Reference No:	2025/65/90113/E
Site Address:	Providence Place, Bradford Road, Cleckheaton, BD19 3PN
Description:	Listed Building Consent for internal and external alterations
Recommending Officer:	Edward Cheseldine

DECISION – GRANT LISTED BUILDING CONSENT

2025/90113 - Providence Place, Bradford Road, Cleckheaton, BD19 3PN

**DRAWING NO.** CJ/24/002/A  
**SCALE.** As shown @ A1  
**DATE.** 9/9/24

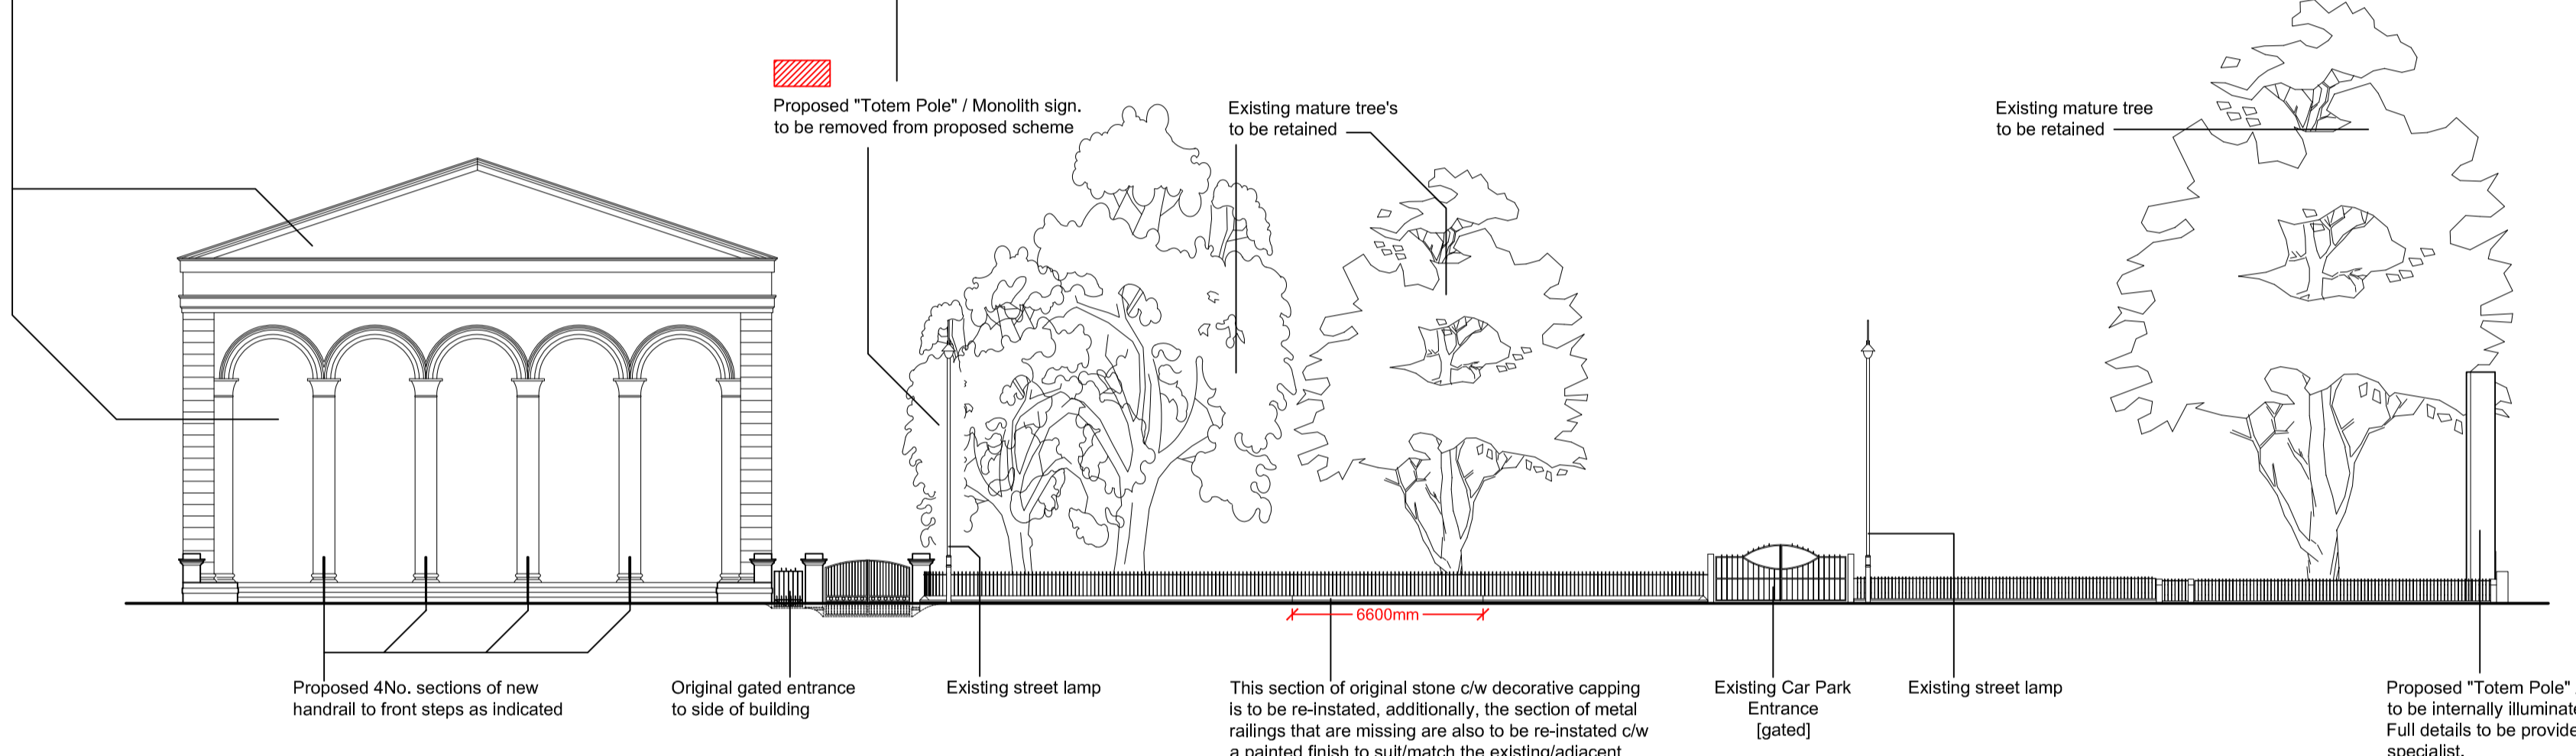
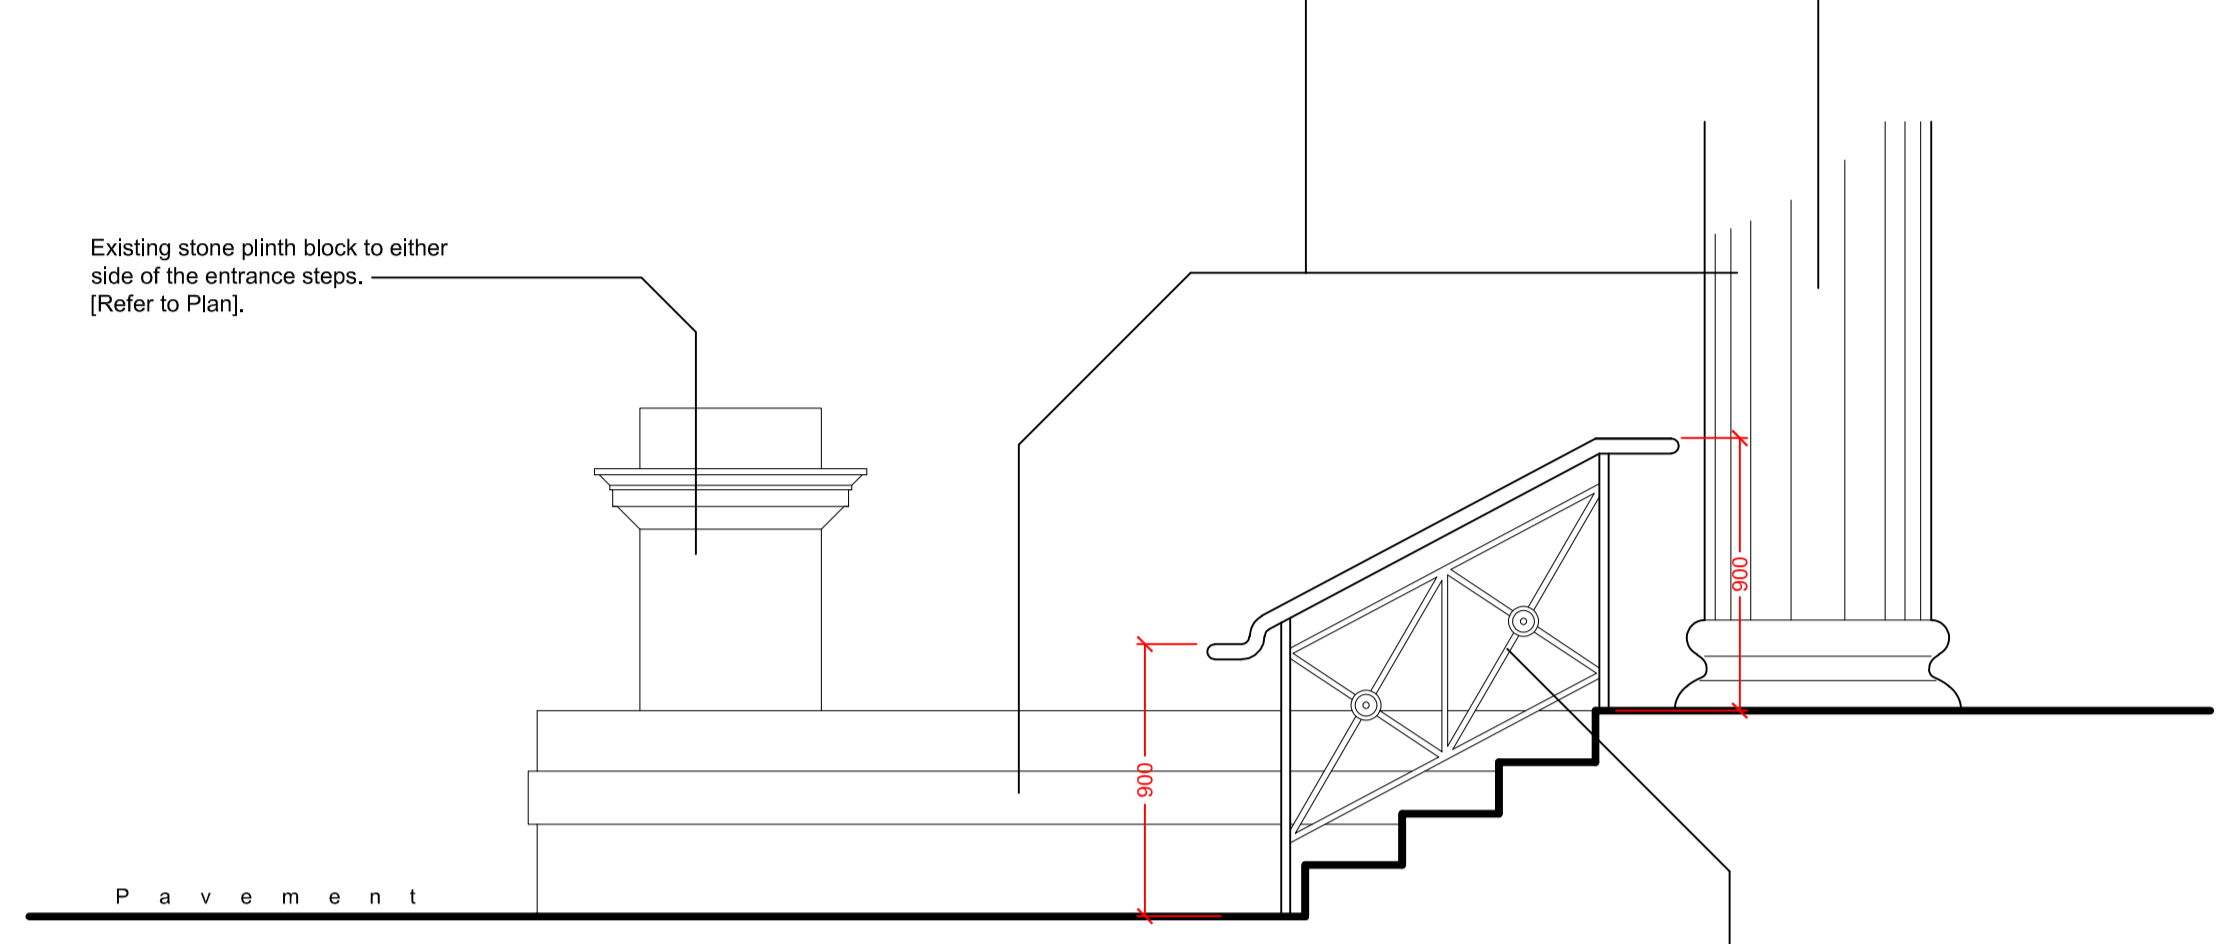
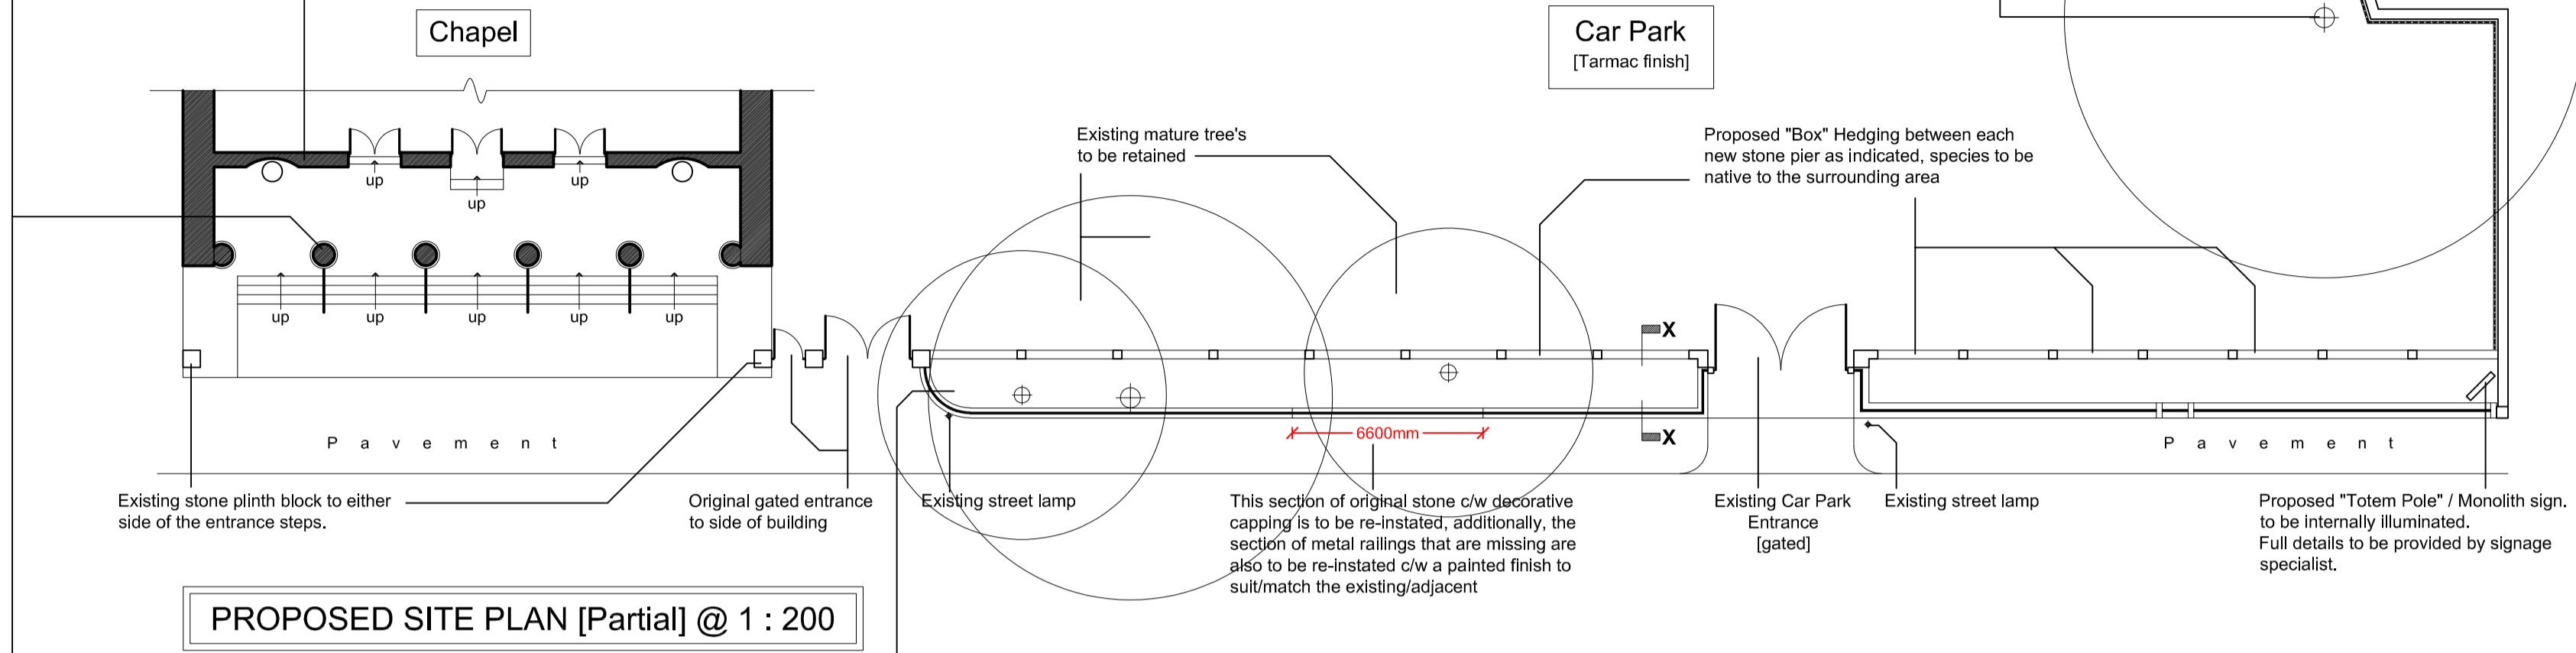
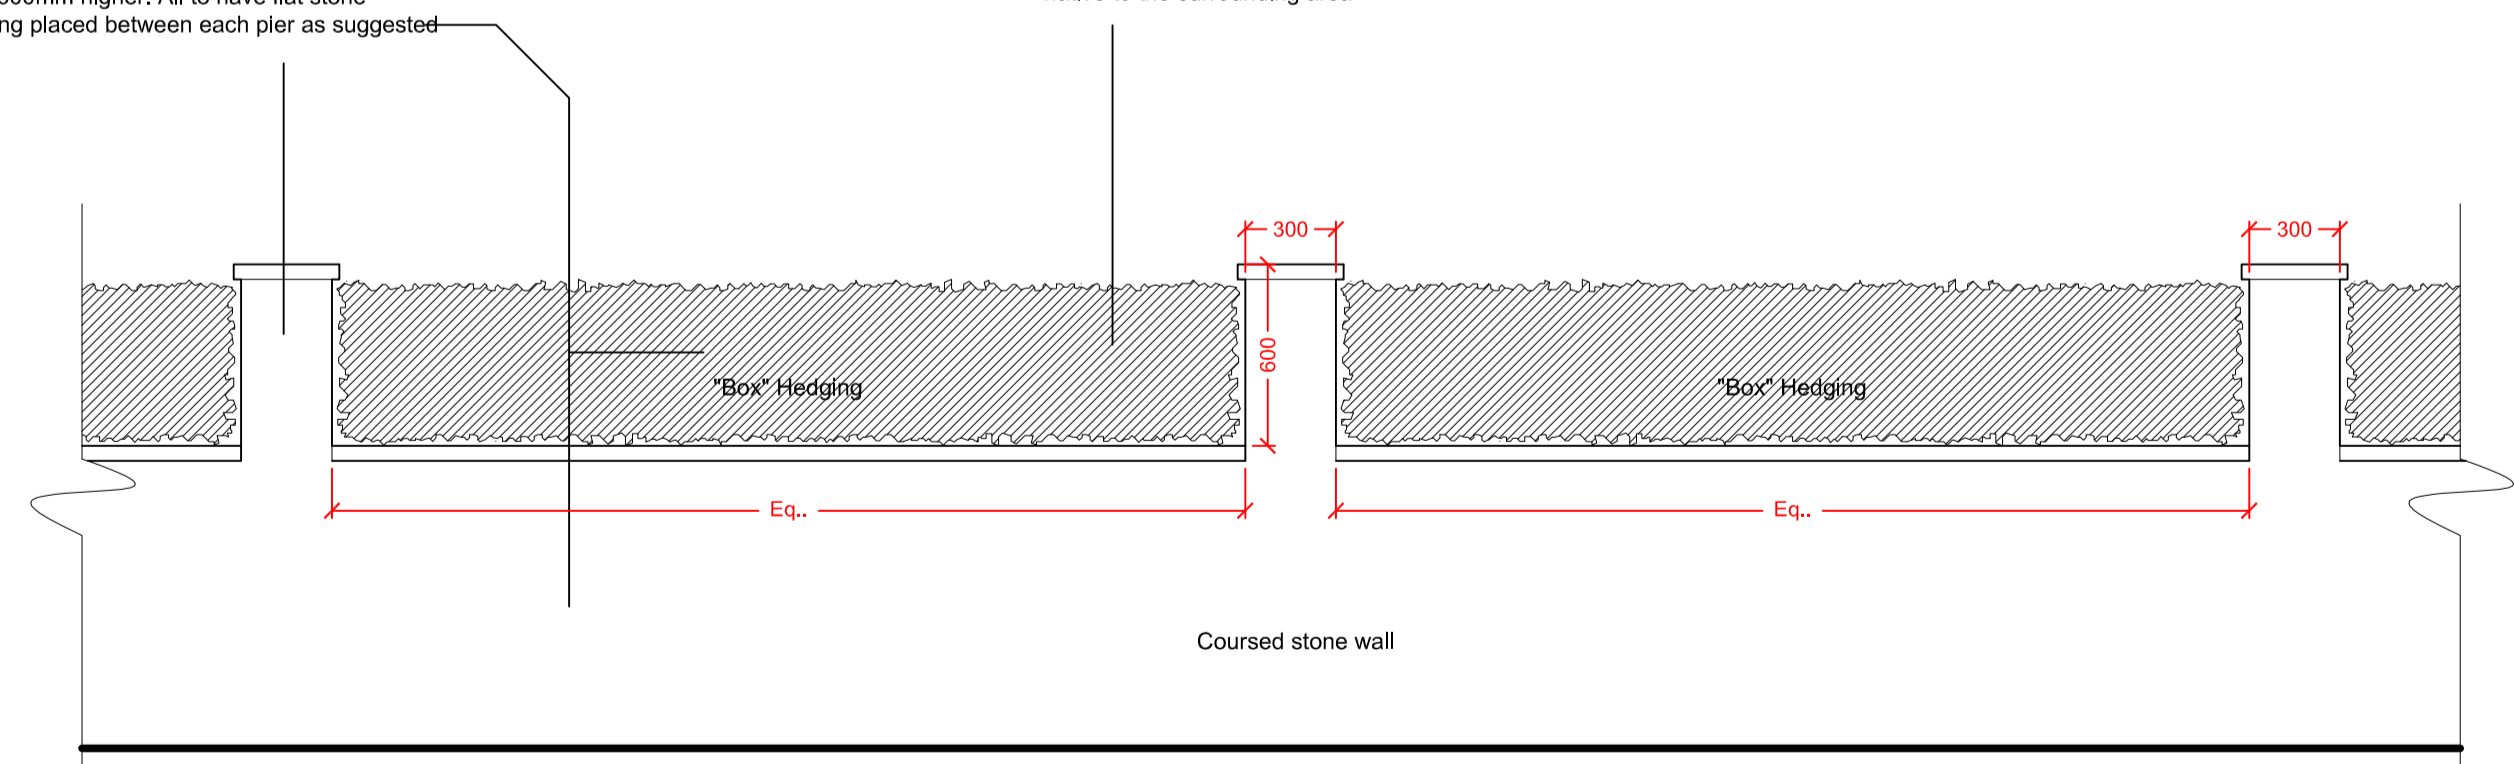
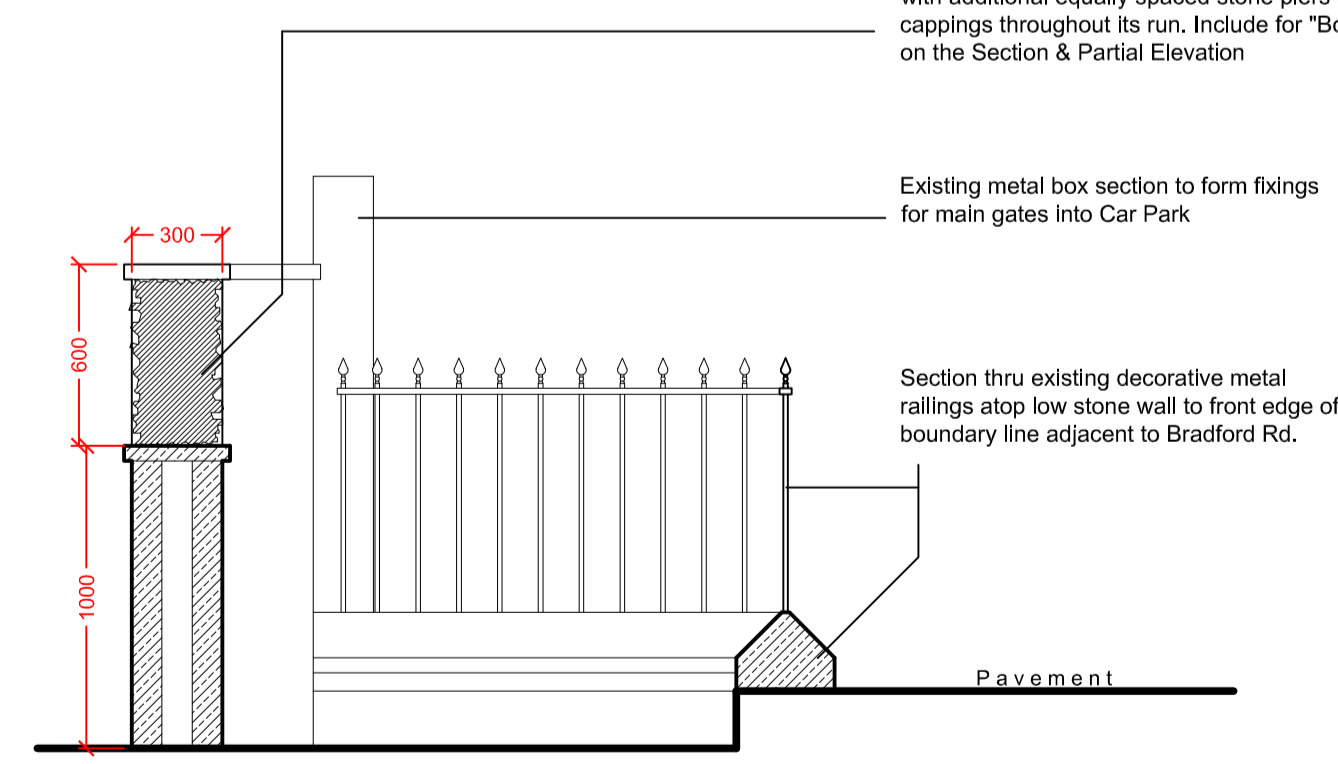
- Removal of proposal of boundary on south-east aspect of the car park. Applicant informed boundary treatments would require planning permission. An application for planning permission was not submitted, therefore the applicant was asked to remove the boundary treatments from the plans.

- No stone cleaning of the building due to its current condition following an on site inspection. Stone cleaning has previously been permitted and the stone was relatively pristine. Stone cleaning can lead to the soft sandstone eroding which may need to be repaired at a later date. Signs of erosion can be found on the bottom of the Corinthian columns showing the brittle condition of the stone.
